Please ask for: Nicola Moore
Email: nicola.moore@arun.gov.uk
Telephone: Ext 37944
Our Ref: A/55/20/CLP
Your Ref:
Date: 8th April 2020

Lawful Development Certificate for a Proposed Use or Development

Development: Lawful development certificate for a single storey rear extension.
Location: Ariston Water Lane Angmering BN16 4EJ

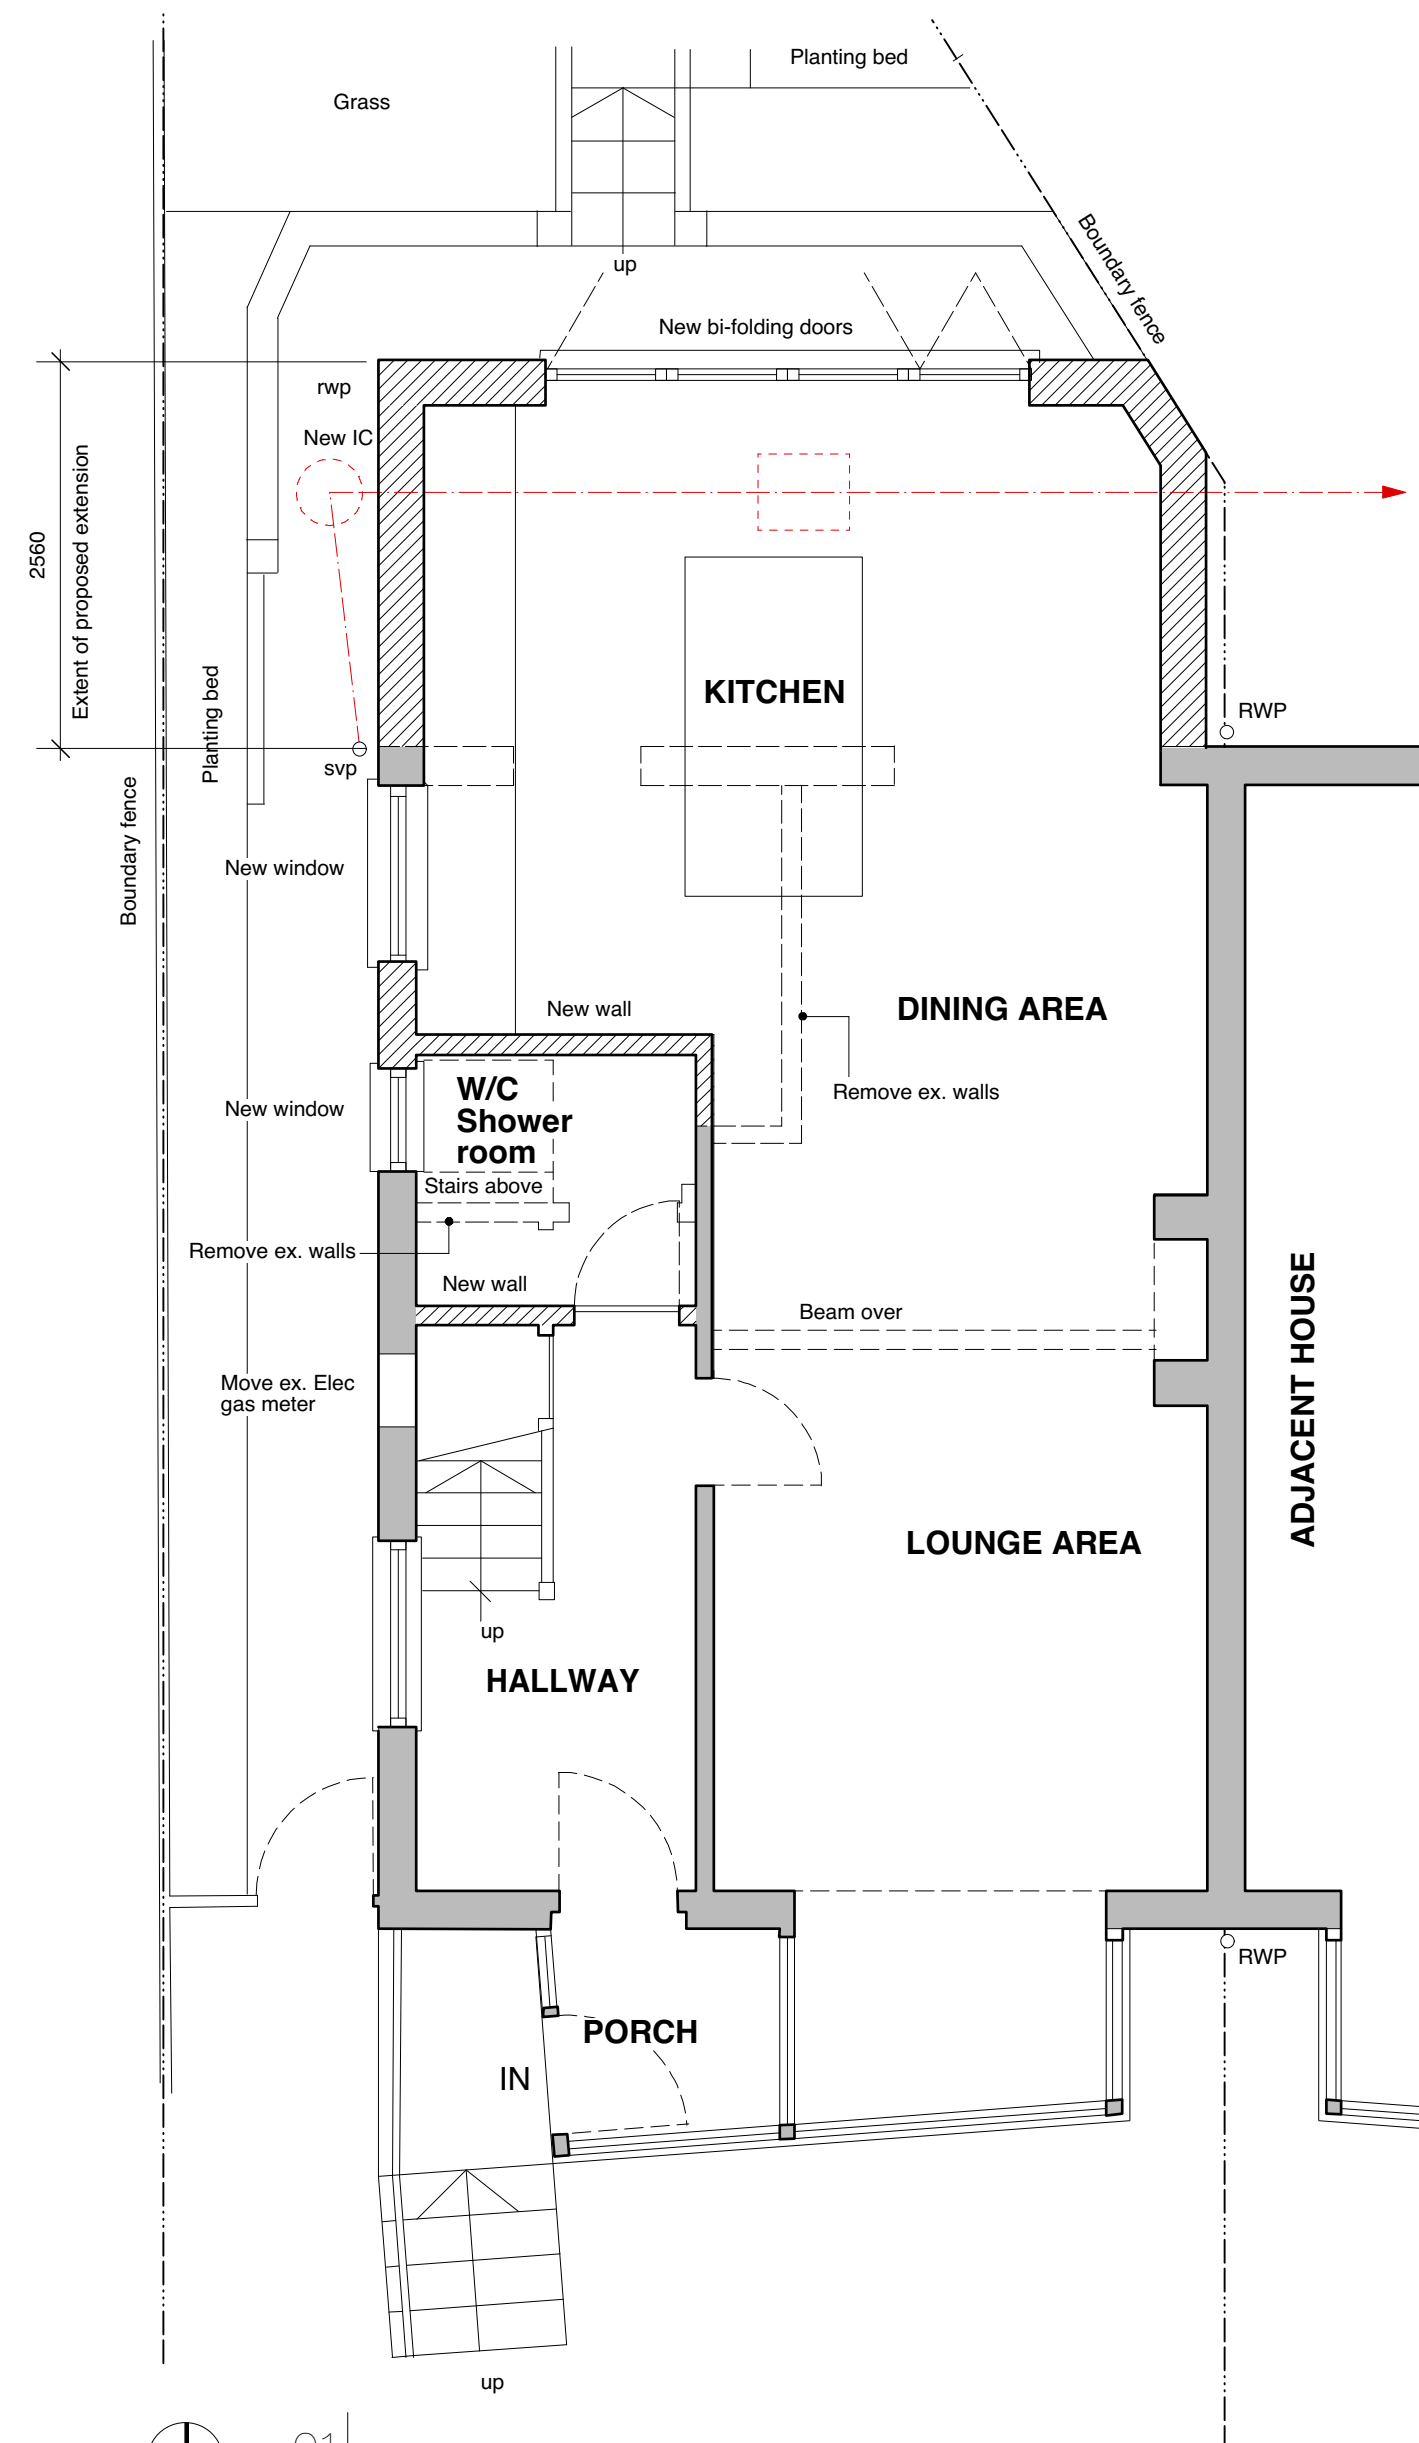
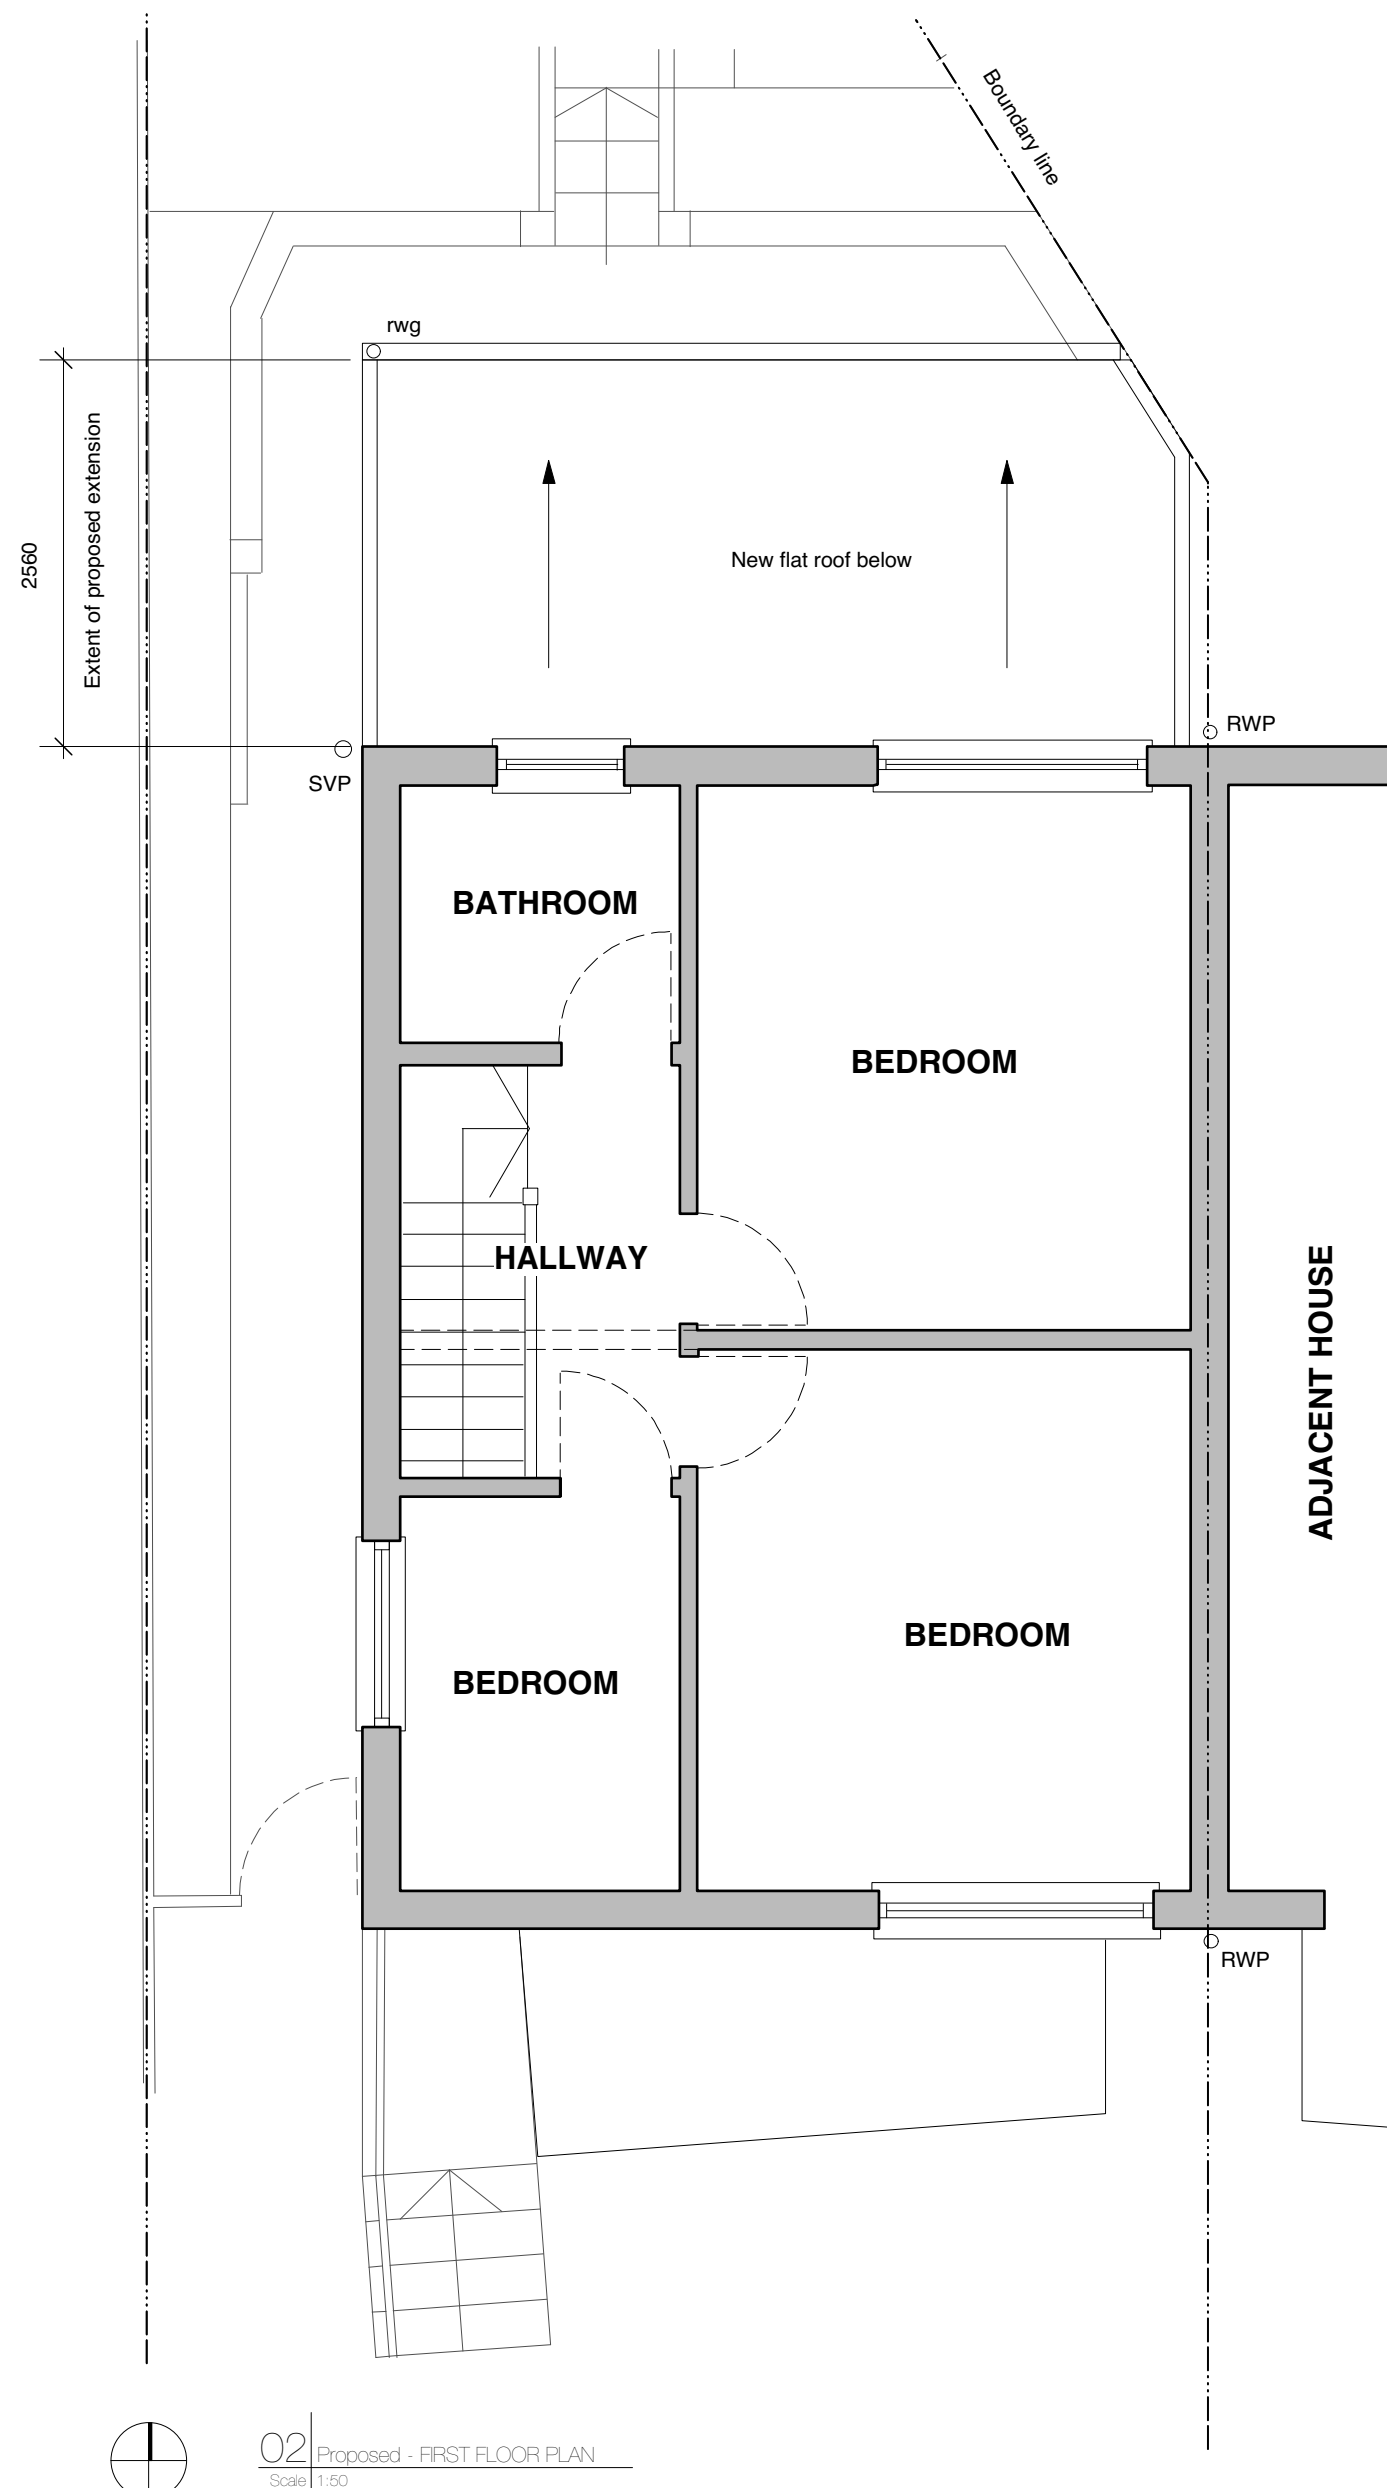
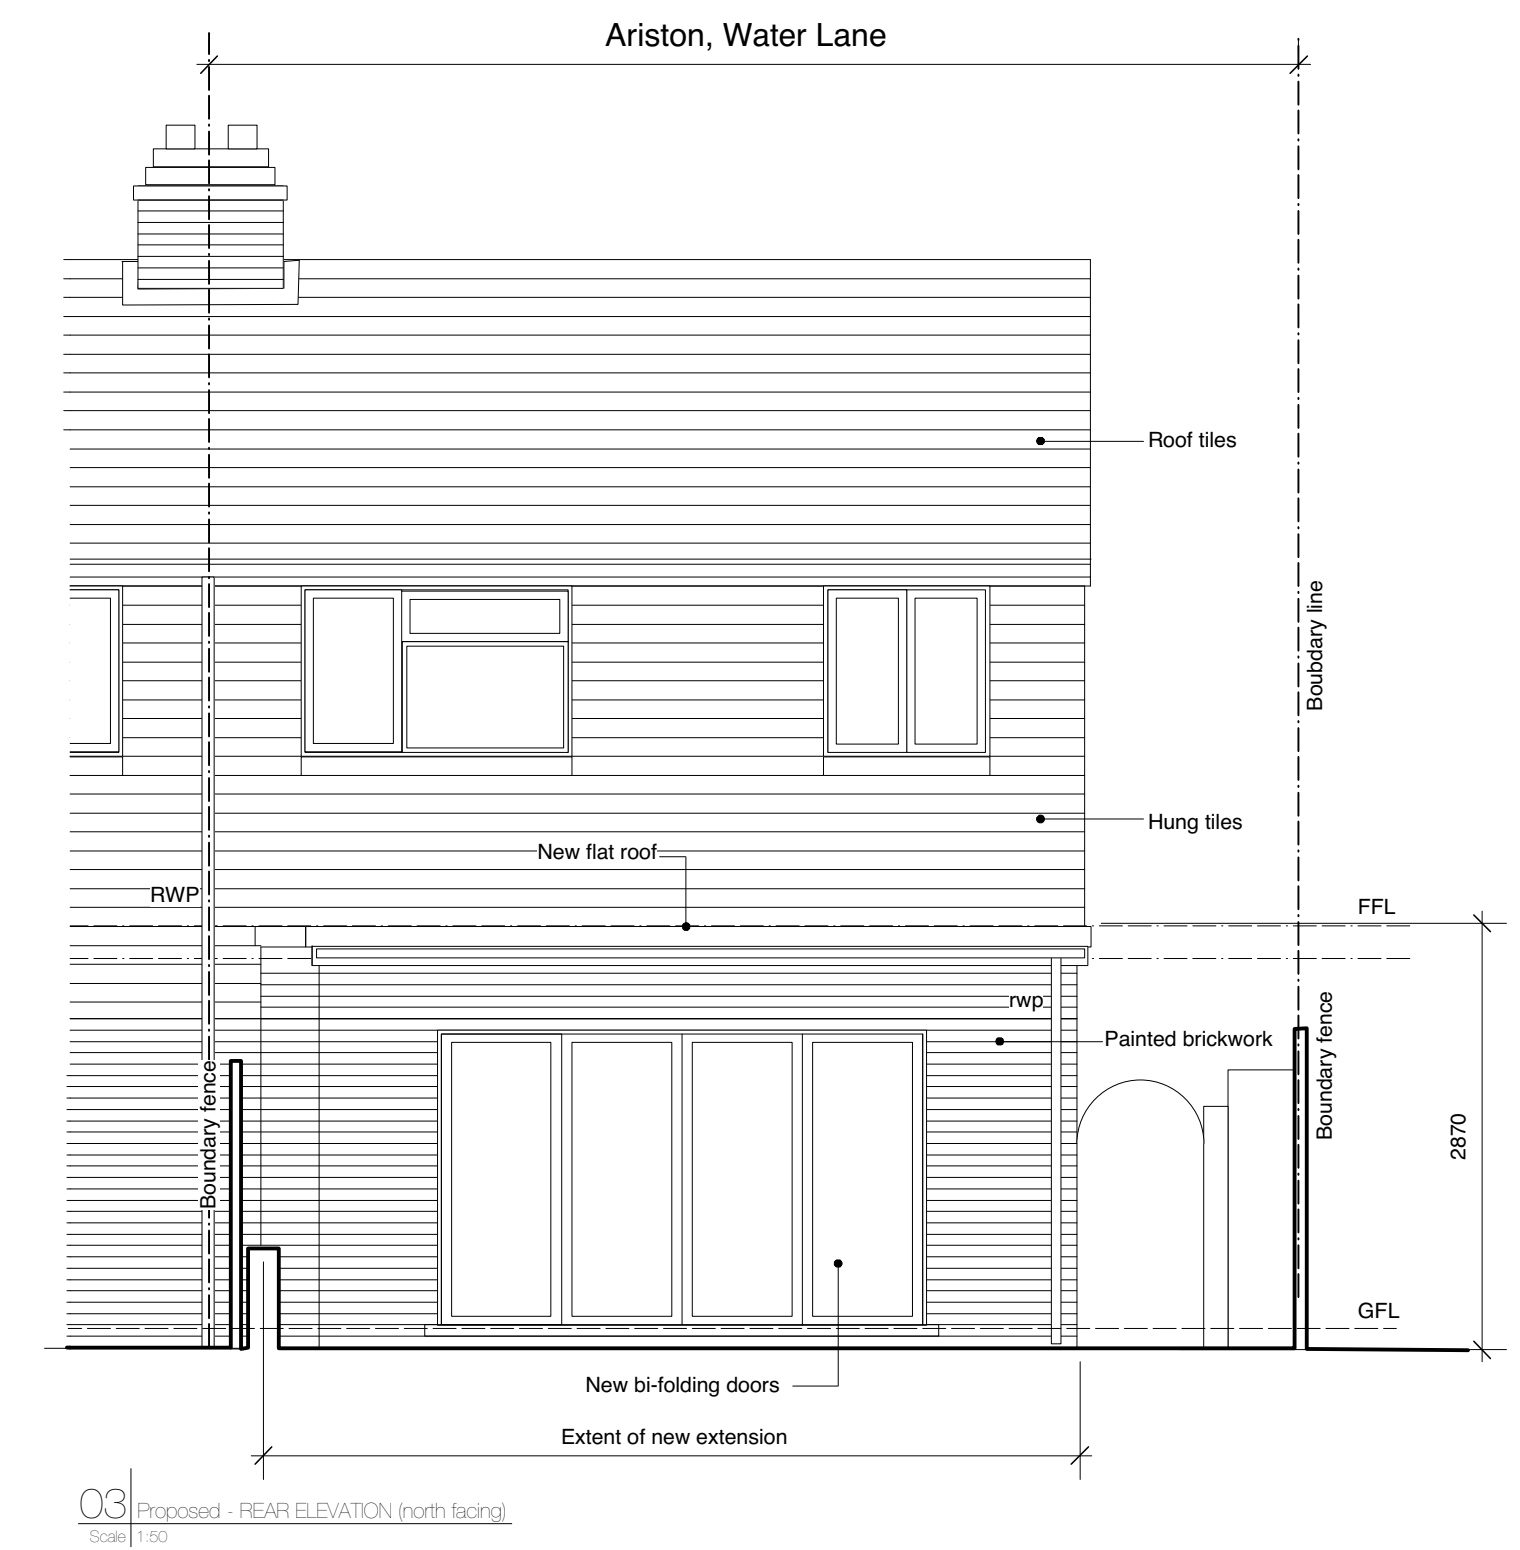
I have measured the bathroom window at 0.9m on the proposed first floor plan and 1.05m on the proposed elevation. Please could you check the measurements, and amend/confirm accordingly.
